A303 Amesbury to Berwick Down

**8.3 (2) – Statement of Common Ground– Historic Buildings and
Monuments Commission for England**

**STATEMENT OF COMMON GROUND – Historic Buildings and Monuments
Commission for England**

Regulation Number:	Regulation 5(2)(q)
Planning Inspectorate Scheme Reference	TR010025
Application Document Reference	8.3 (2)
Author:	A303 Project Team, Highways England, and Historic England

Drawing Title
STRUCTURES DRAWINGS
WESTERN TUNNEL PORTAL
REGULATION 5(2)(o)
SHEET 8 OF 13

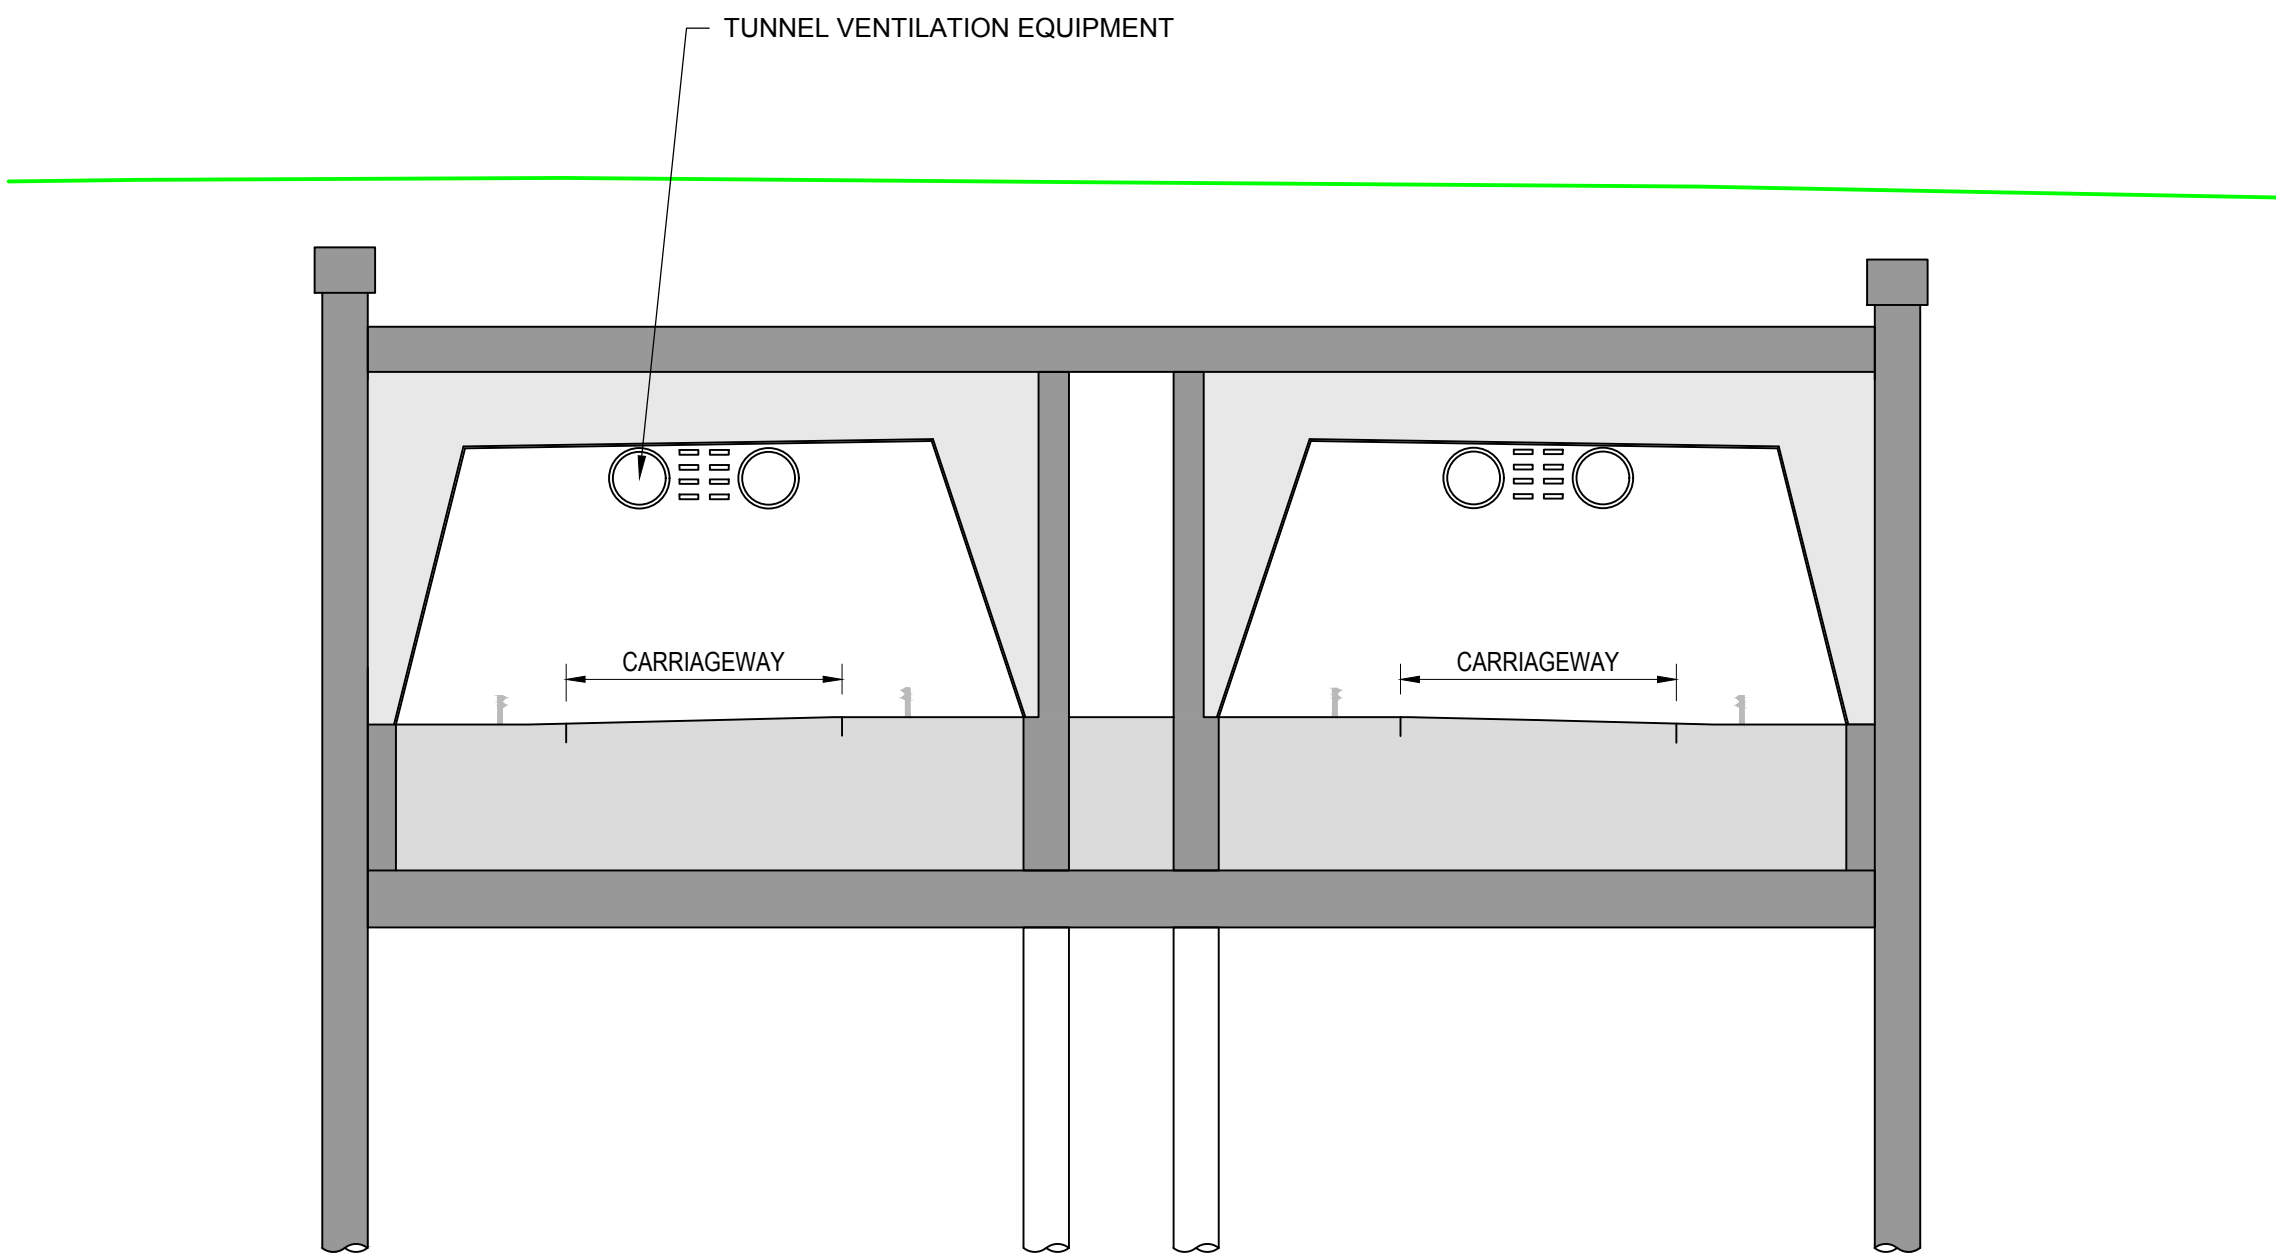
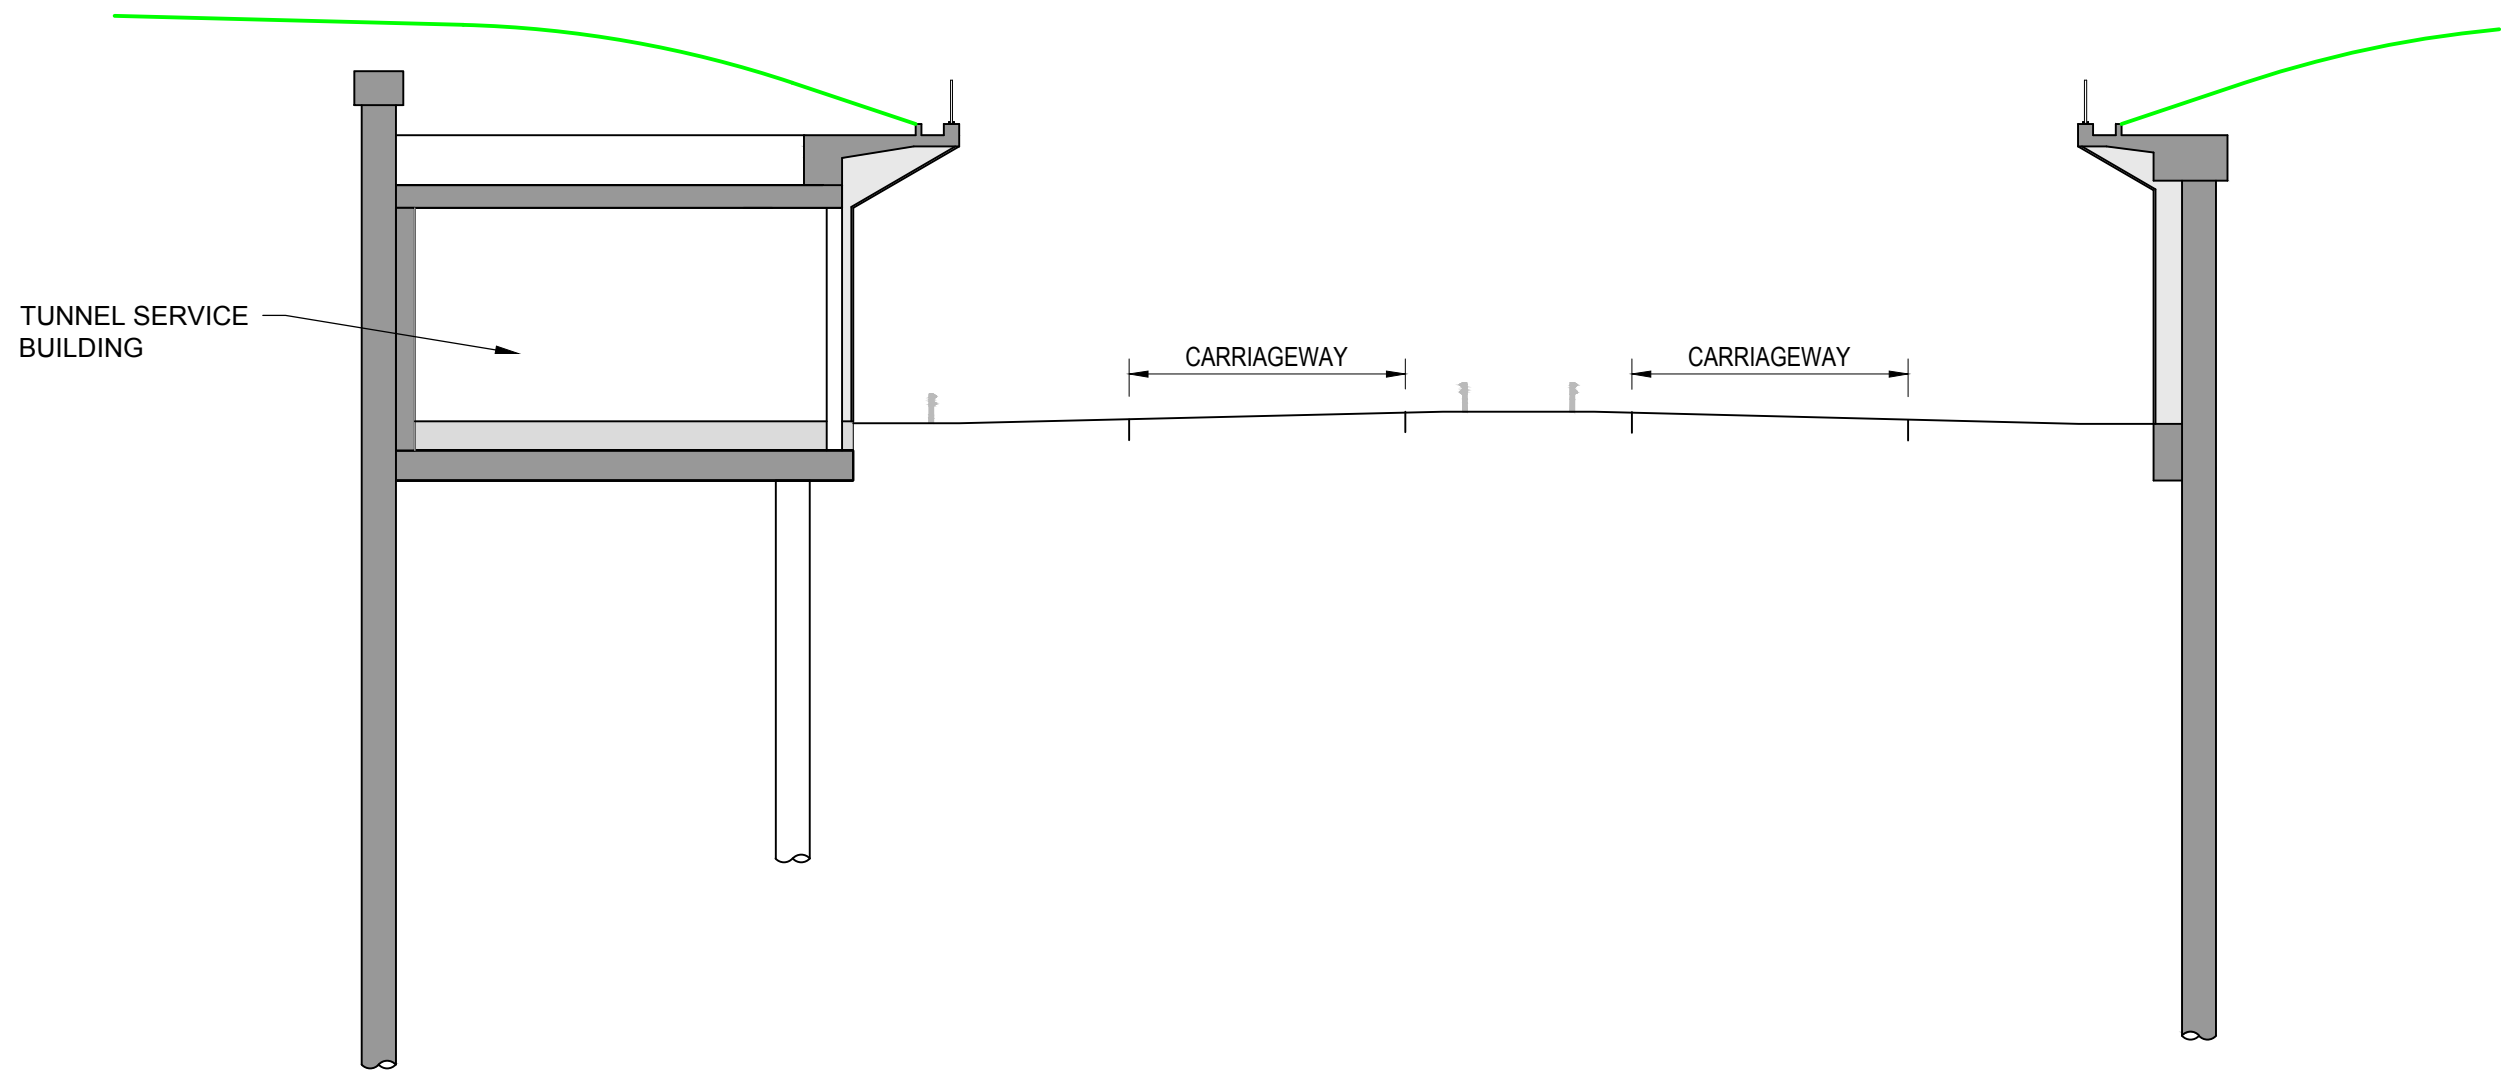
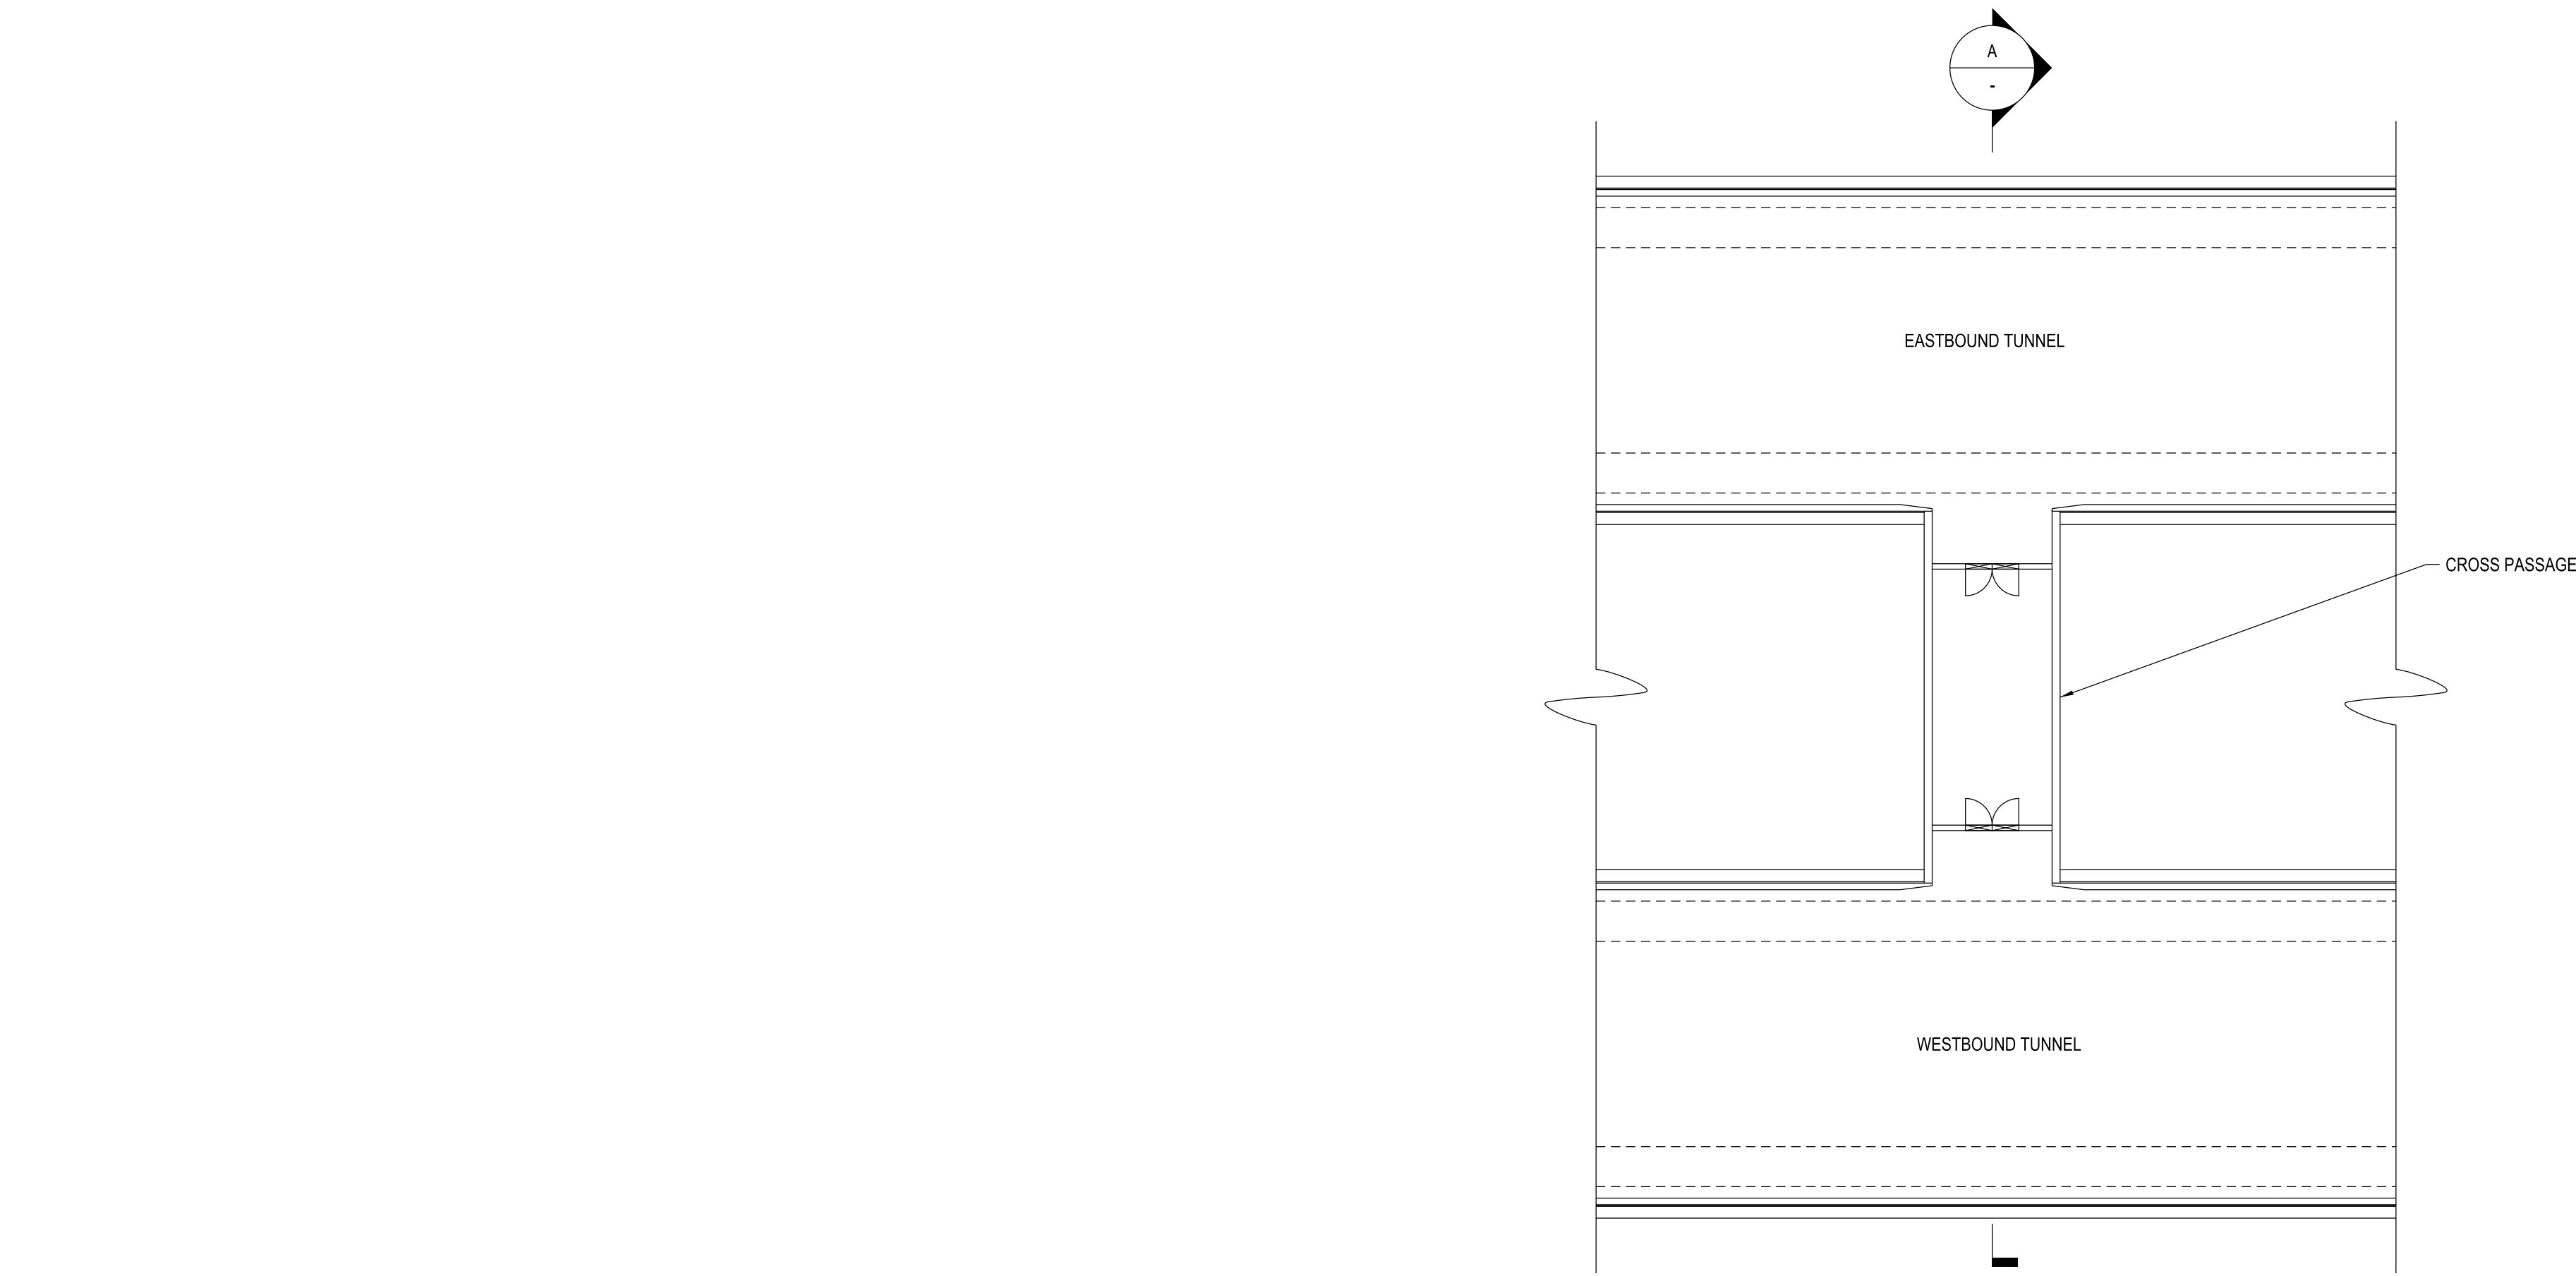
3.9	[RR-1897] [REP2-101]	<p>Detail of key engineering elements of the Scheme</p> <p>Areas of the Scheme where further refinement or illustration of effect is required to avoid and/or minimise harm to OUV and significance:</p>	Paragraphs 1.13 (a) (b) (c) (d) and (e)	<p>HBMCE states that there is an absence of detailed proposals for lighting, signage, fencing, drainage, balance ponds, landscaping including tree planting in and adjacent to the WHS;</p> <p>HBMCE state that detail is required in relation to key engineering elements of the Scheme, including the relocated Longbarrow Junction, the tunnel approaches in retained cuttings and tunnel portals. This additional information should address engineering design, levels in relation to existing topography, the approach and selection of materials and surface treatments, landscape integration, and visibility of associated infrastructure such as lighting and signage.</p> <p>Detail is needed in relation to Green</p>	<p>Highways England considers that the application has provided sufficient information to allow Historic England to understand, engage with and respond to and comment on the Scheme and that a number of the points of discussion will be addressed as part of the detailed design of the Scheme.</p> <p>Further details of junctions, the tunnel approaches and portals (including engineering design, levels in relation to existing topography, approach to materials selection and surface treatments and landscape integration) will be developed through the detailed design process. This will enable the best opportunity to draw on the skill and experience of the</p>	It is agreed between Highways England and HBMCE that the issues HBMCE has raised have been broadly addressed.'

Issue Ref	Doc Ref	Paragraph Reference	Sub-section	HBMCE Comment	Highways England Response	Status
	[REP6-053]	ExA question	Page 10	<p>Bridge 4, including design detail, landscaping proposals, the ensured confirmation of its width at 150m and of its positioning.</p> <p>Detail is needed in relation to the tunnel canopies, including design detail, confirmation of their positioning, and landscape proposals to understand how they will be integrated into the landscape.</p> <p>A greater degree of precision is needed in relation to the actual positioning of the tunnel portals given the sensitivity of the landscape. Historic England considers the limits of lateral deviation westwards in the first draft DCO of 200m for the western portal to be unjustified at this point.</p> <p>Detail is needed in relation to the management of light levels (both from infrastructure and vehicle headlights), because of effects of light on the night time historic environment, in particular, in relation to the tunnels and retained cuttings within the SAAS WHS.</p> <p>In our Written Representations</p>	<p>contractor to be brought fully into the detailed design and implementation phase and therefore greatest potential for innovation and latest practice and technology to be fully considered at the stage immediately before implementation.</p> <p>The OEMP, the final version of which was issued at deadline 9, [REP9-013] includes a design vision together with a set of design principles for key elements of the Scheme. Highways England, and its Contractor once appointed, will consult the SDCG on the external appearance of the following elements of the Scheme within and visible from the World Heritage Site:</p> <ul style="list-style-type: none"> a) The tunnel service buildings (Work No.1D(ii)); b) Portals structures (Work Nos. 1E(ii) and 1G(iii)) including lighting, retaining walls (part of Work Nos. 1D(ii) and 1H(ii) and 1H(iii) and Green Bridge Four (Work No.1d(i)); and c) Public rights of way (new and interactions with existing), including pedestrian,
